PORTLAND MAINE

December 17, 2012

RE: Maritime Landing Project (Federated Companies) – Plan Comments

This letter is intended to provide City staff comments on the Maritime Landing concept plan presented at our meeting with the Federated development consultant team on December 5th. We received one copy of the plan at that meeting while additional copies were distributed to the City on December 10th. The reviewed plans were prepared by DeLuca Hoffman Associates. Public Services notes that the plans are conceptual so comments are very preliminary until more detail can be provided. Also a soil analysis study is expected to be undertaken shortly which may further inform our initial comments. Public Services may have additional comments beyond those outlined in this letter, so we will forward review comments to you as soon as we receive them. Note that these comments are based on that version of the plan and do not reflect any changes you may have made to it since that time that may respond to some of these comments.

**DETAIL FOR WATERPROOF MEMBRANE
ALONG THE BACK FACE OF THE WALL**
SCALE: 1" = 2' Horiz., 1" = 4' Vert.

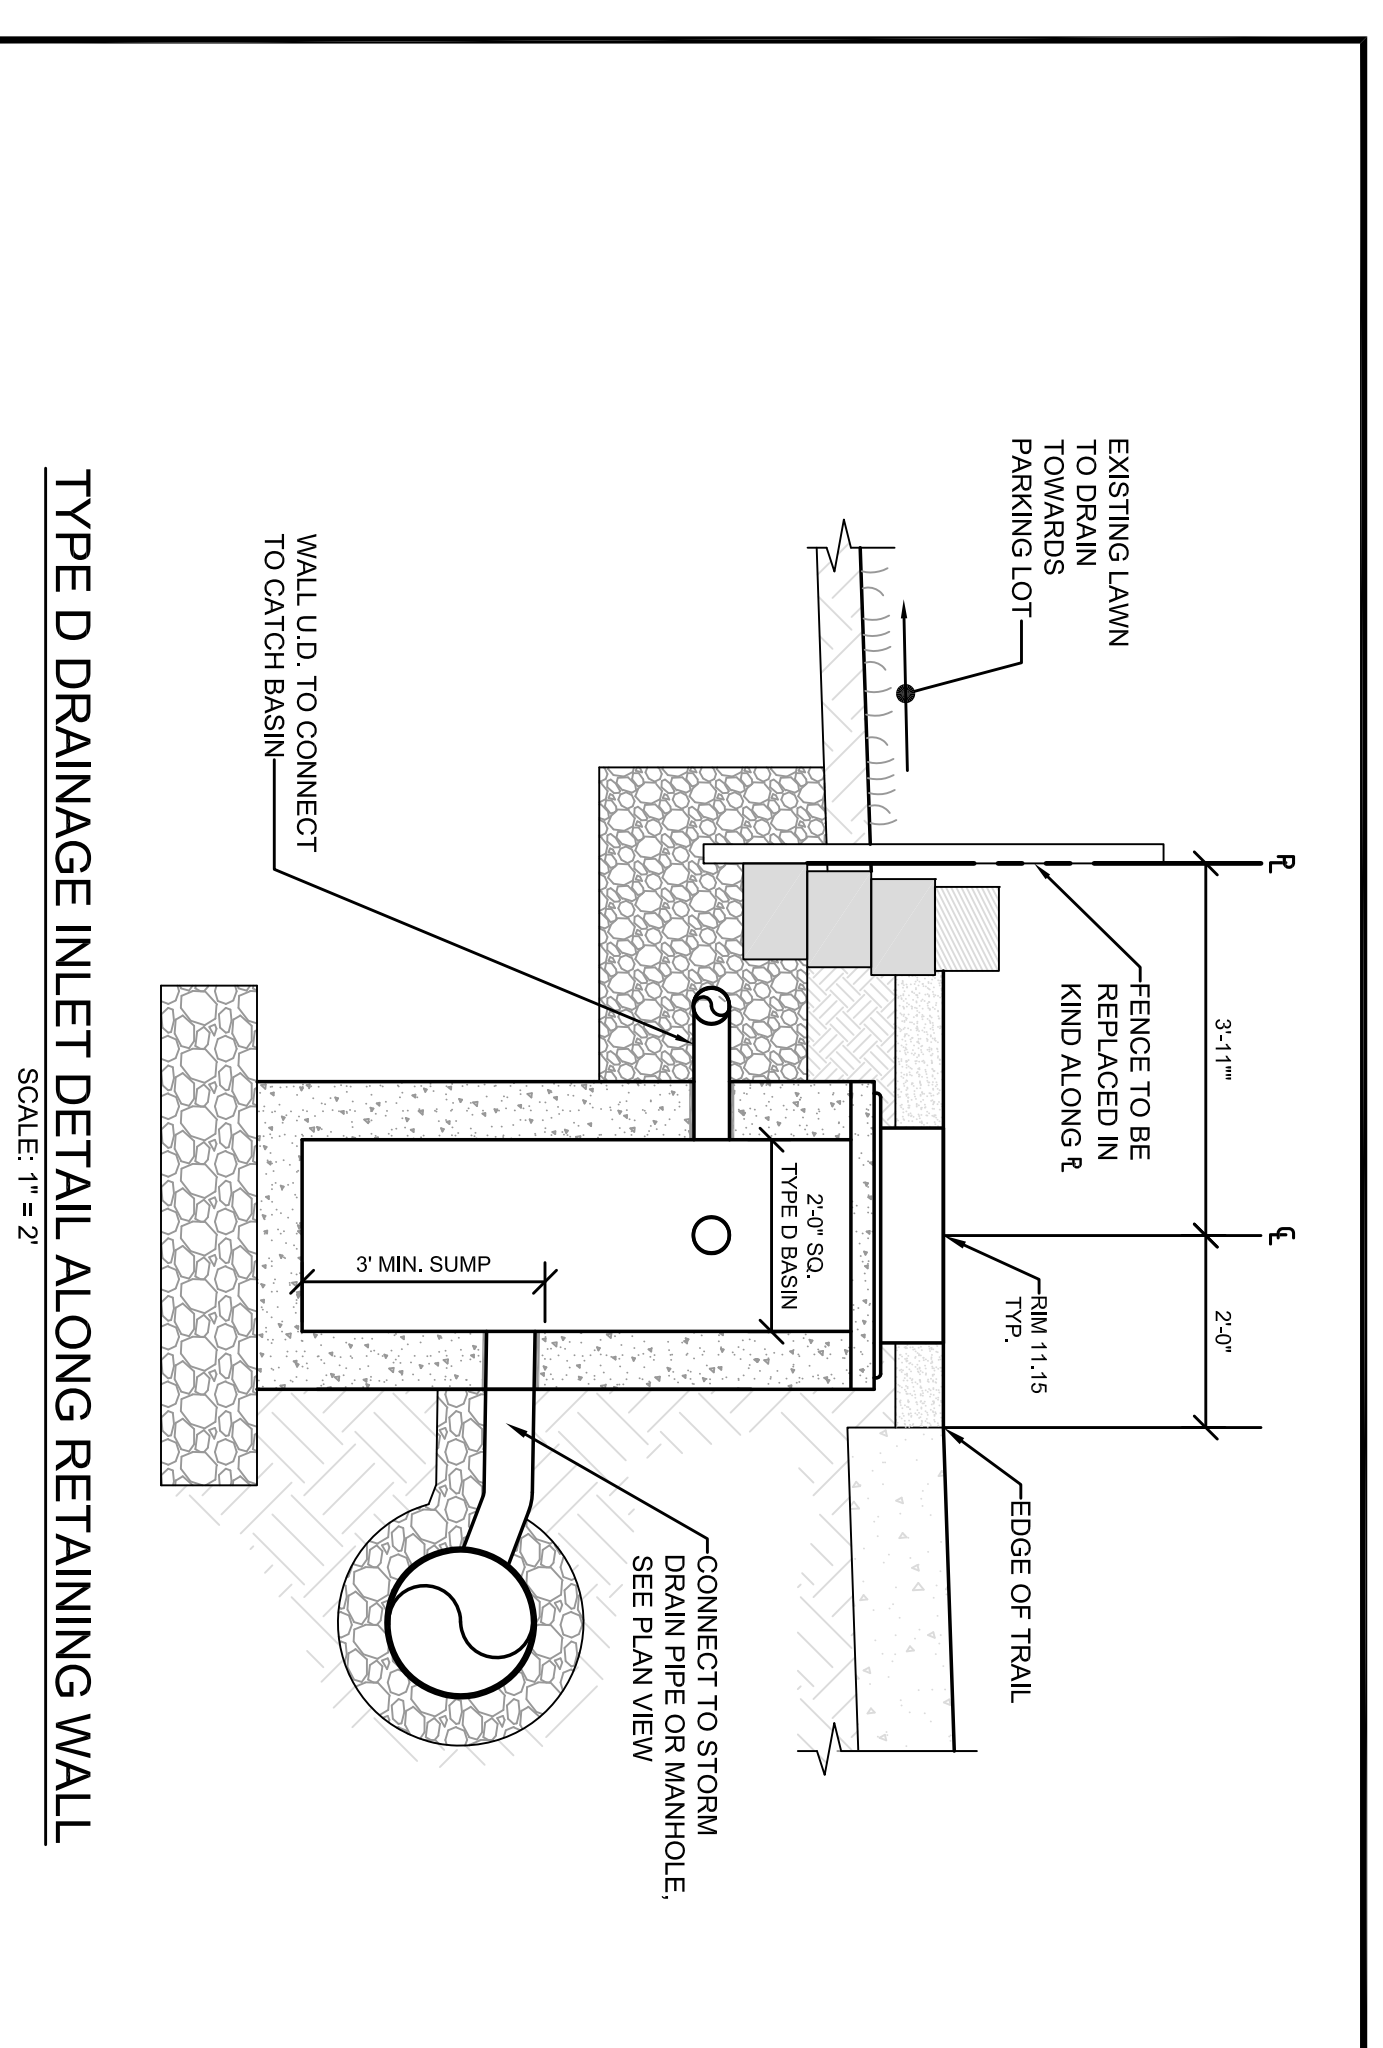
3. **Bayside Trail Retaining Wall:** The retaining wall shown along the northerly property line of the trail adjacent to the DHS/Planet Fitness parking lot is very close to the property line. Any grading or temporary construction easements that may be required from the abutting property owner will likely be problematic. The property owner has had extensive conversations with the City in the past concerning trail construction activities undermining the stability of the fence and or the adjacent slope. Also how high is the proposed retaining wall and what type of material are you considering for the wall? The City recommends that the preferred design not include a retaining wall.
4. **Shifting of Buildings into Trail Space:** The revised plan shows shifting proposed buildings over the subdivision lot lines and into the trail space.
